Response to:
Applicants Written Summary of the Applicant's Oral Submissions – ISH 2

2. Health and Safety including BESS

## **Environmental Statement Figure 10.5: Site Access Locations**

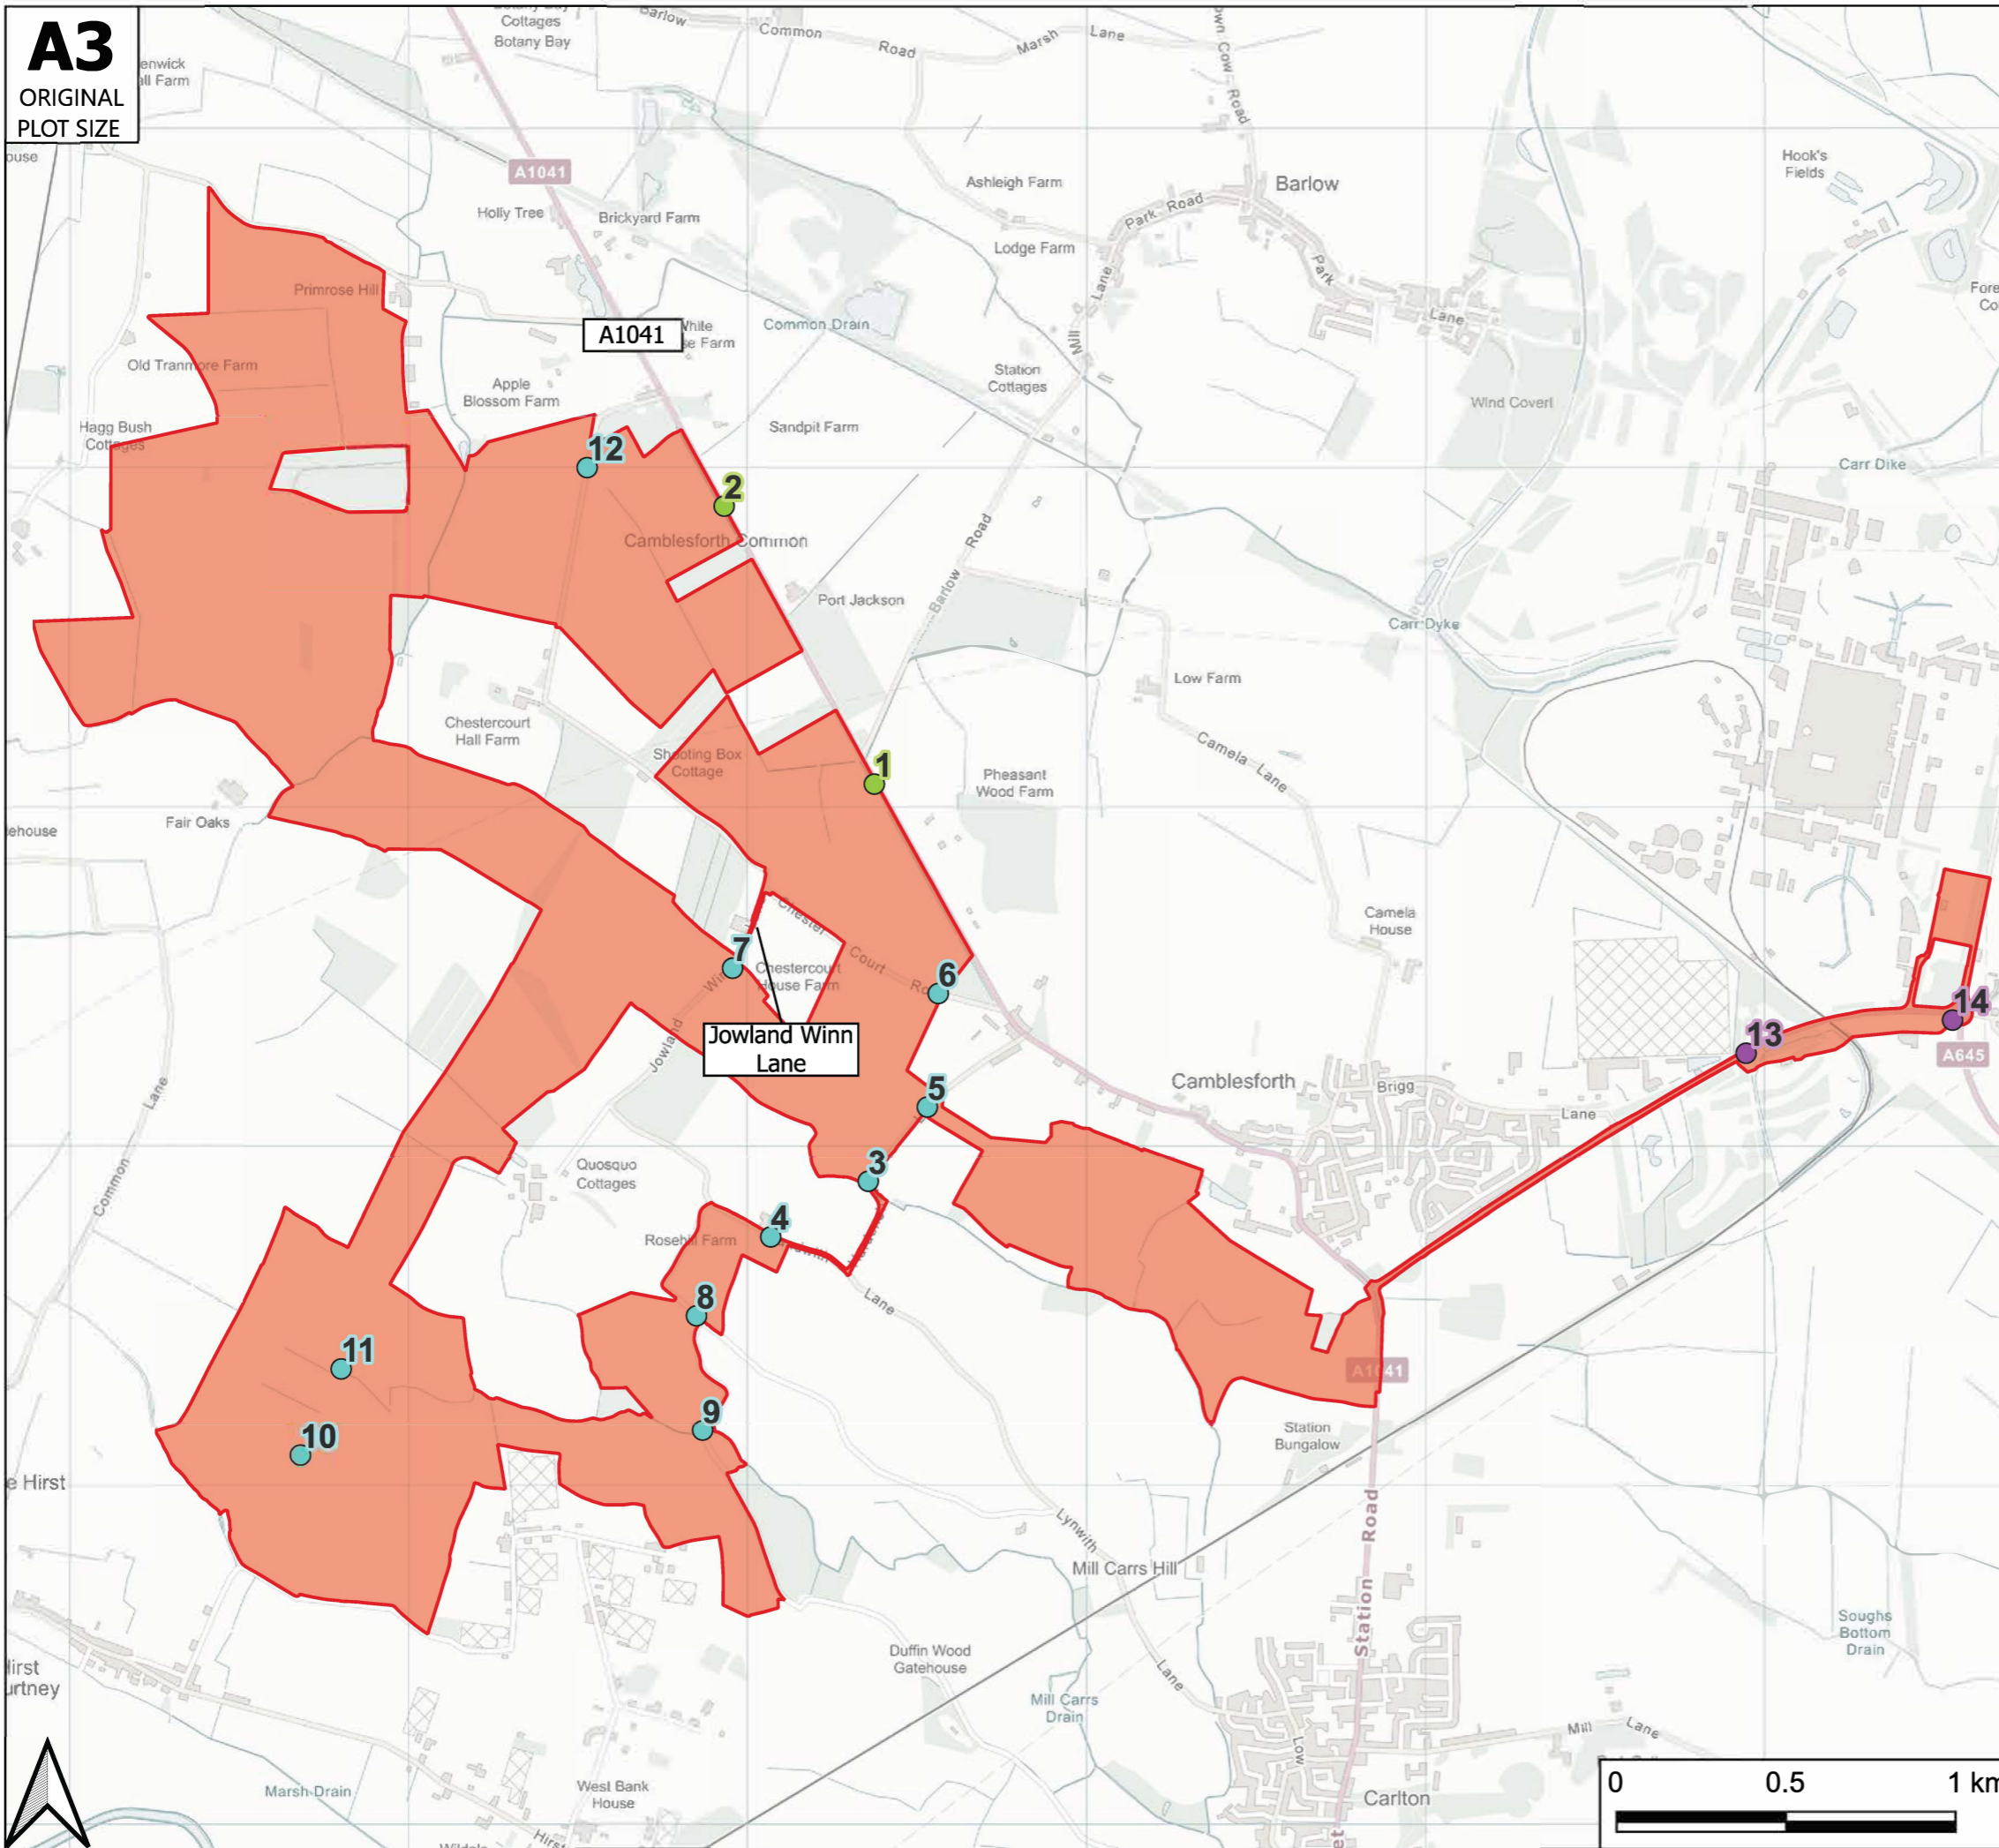
- That the recommended distance of 6 metres between each BESS would be adhered to?
- There would be at least 2 points of access to the BESS site so that firefighters can enter the site whatever way the wind is blowing?
